CITY OF ALBUQUERQUE

September 25, 2019

Re: 4801 Lincoln Rd. NE
4801 Lincoln Rd. NE, 87109
30-Day Temporary Certificate of Occupancy
Transportation Development Final Inspection
Engineer's/Architect's Stamp dated 01-15-19 (F17D024A)
Certification dated 9-19-19

AS-1.1

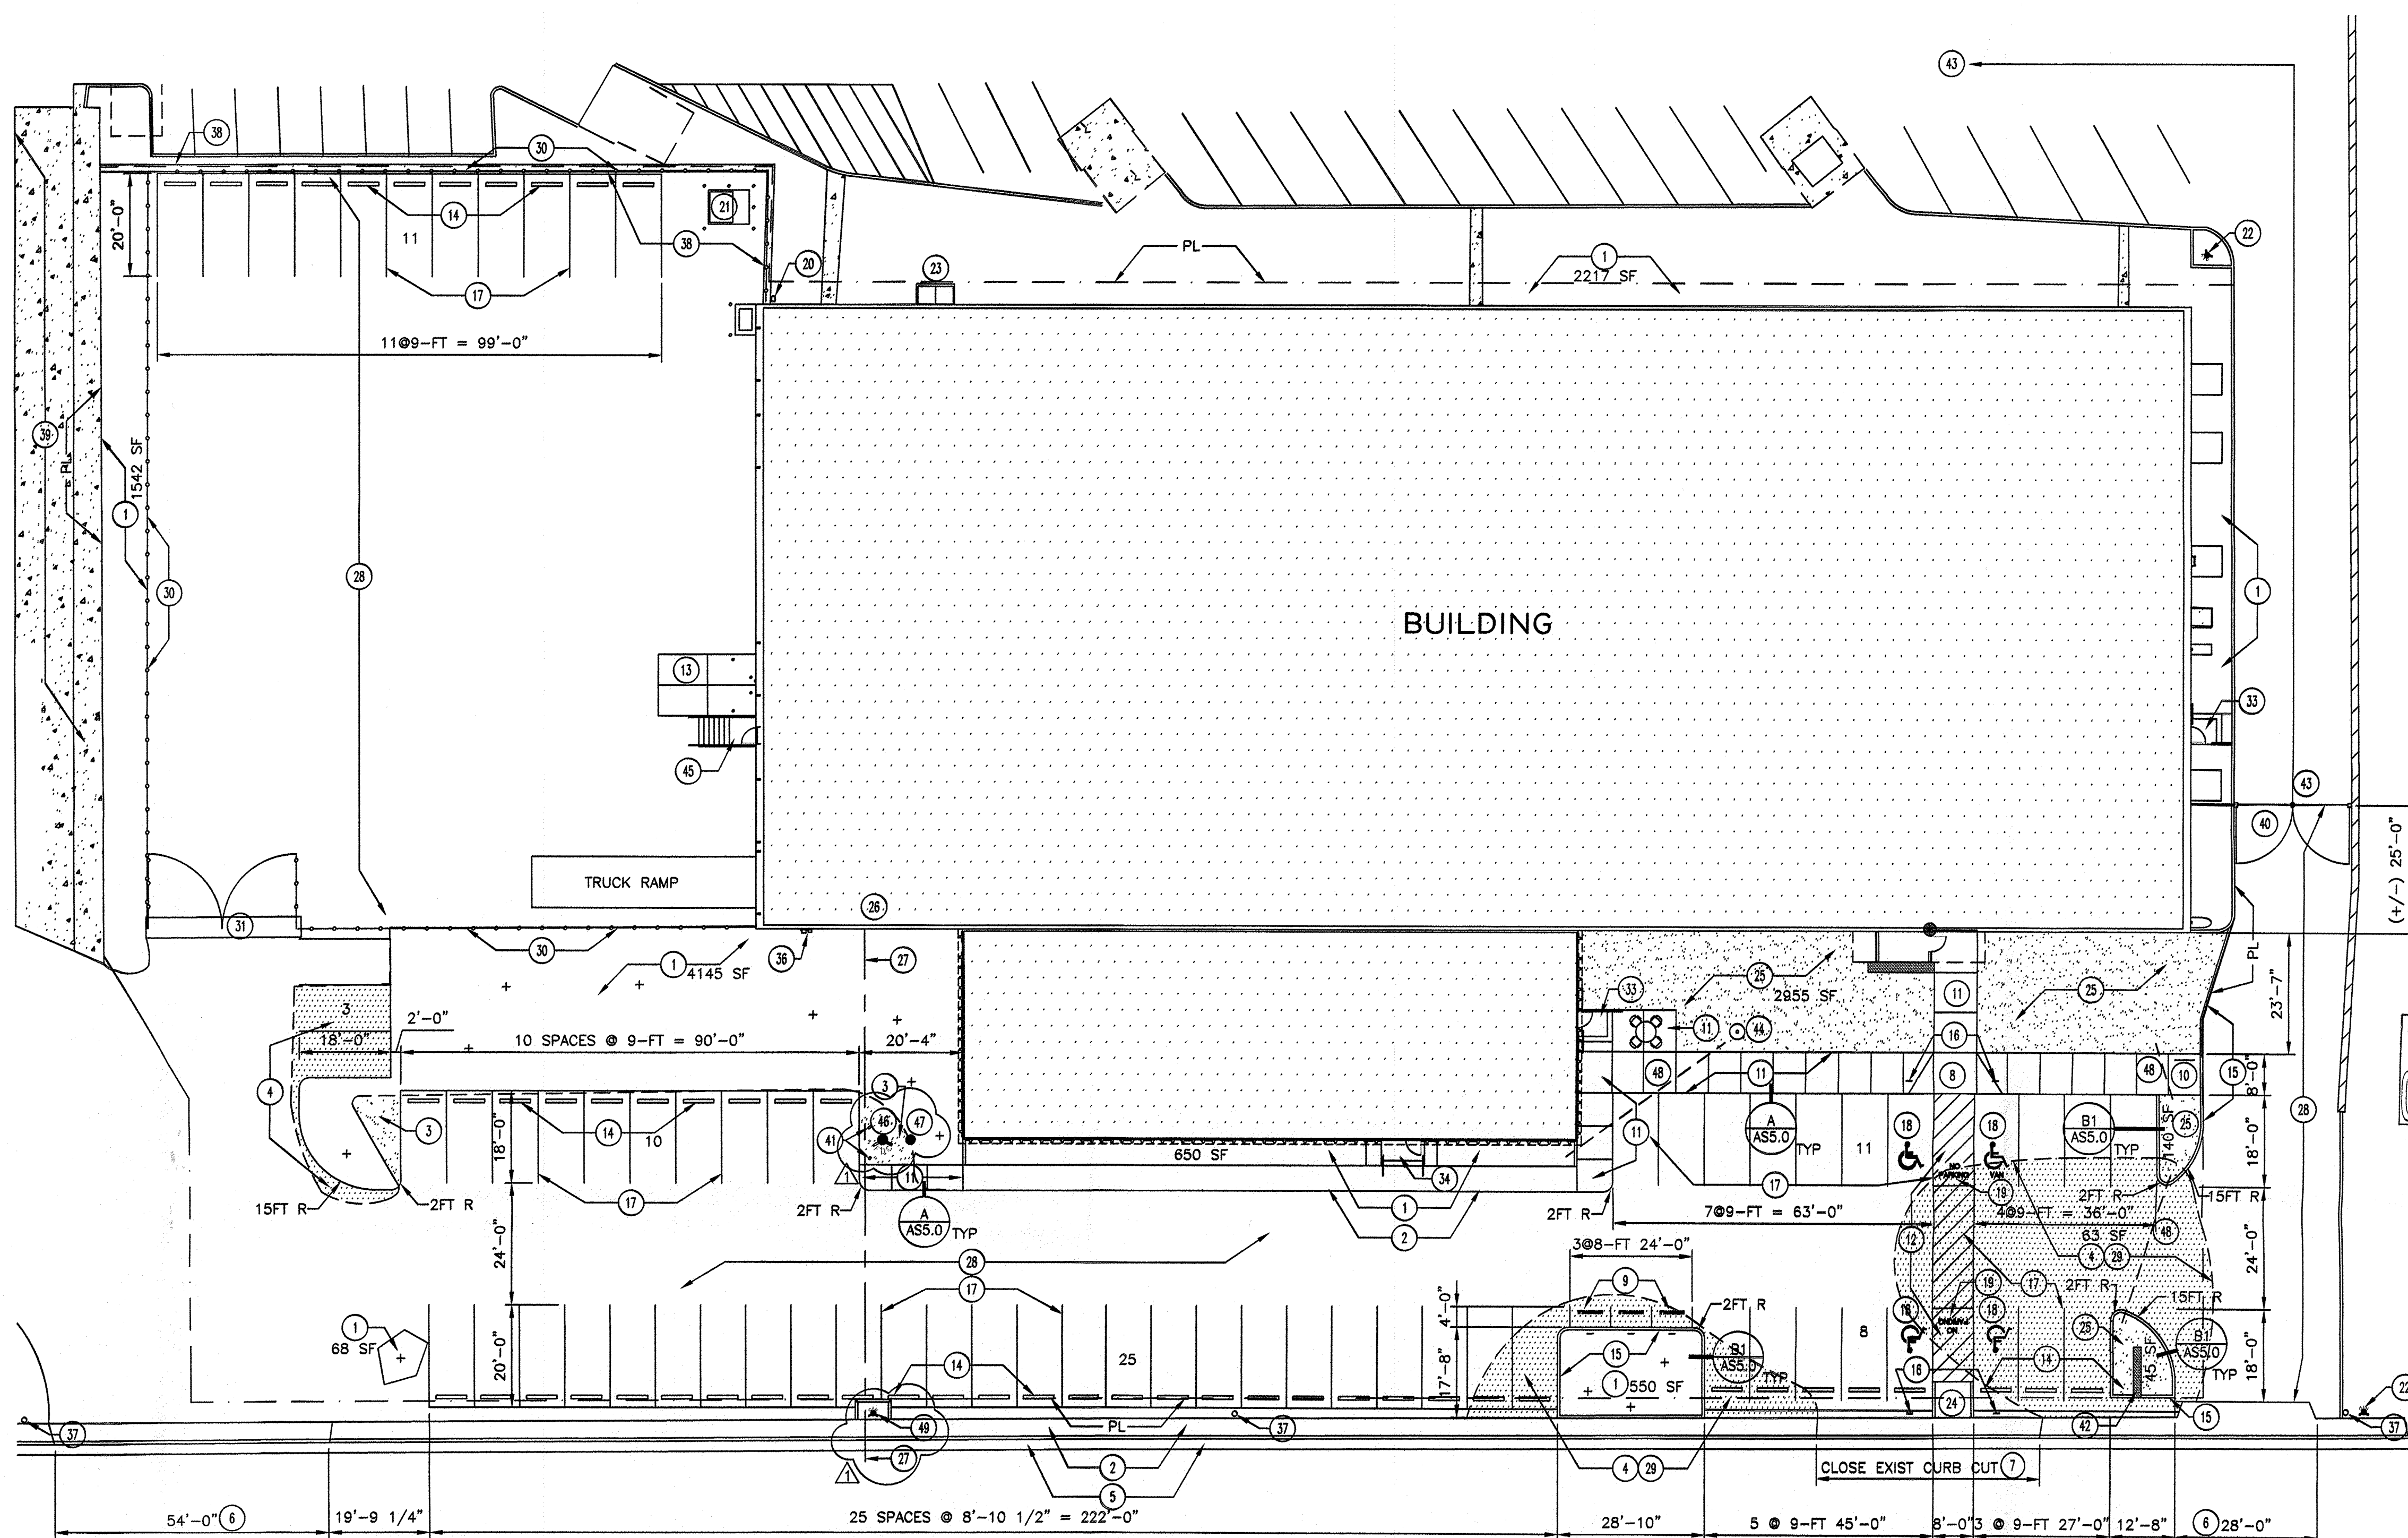
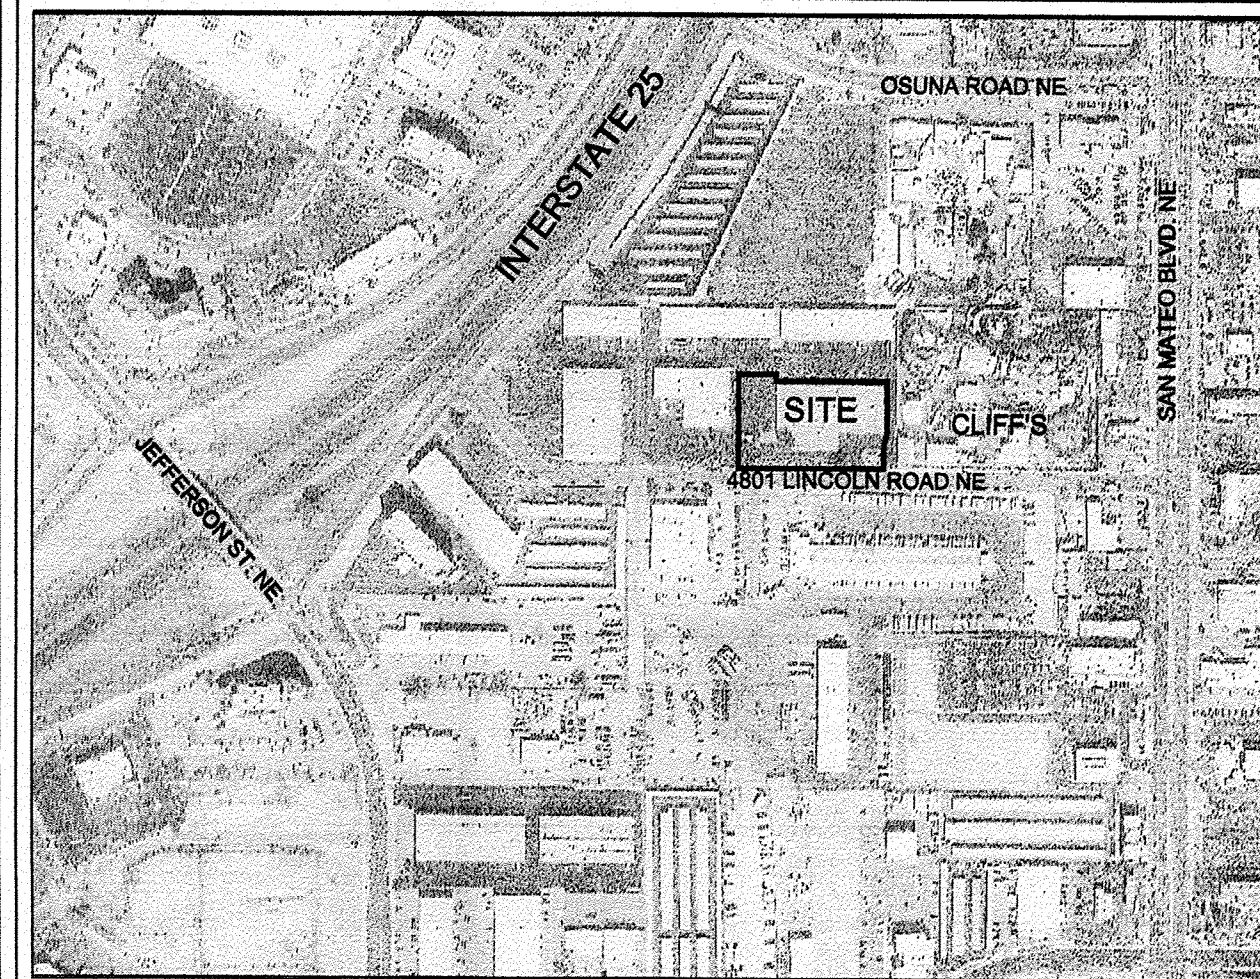
- Label the compact parking spaces by placing the words "**COMPACT**" on the pavement of each space. (Parking stall with fire hydrant. See attached photo)
- Motorcycle parking spaces shall be designated by its own conspicuously posted upright sign, either free-standing or wall mounted per the IDO. (Each stall requires its own sign)
- Please remove security fences, porta potty, construction equipment and trash container.
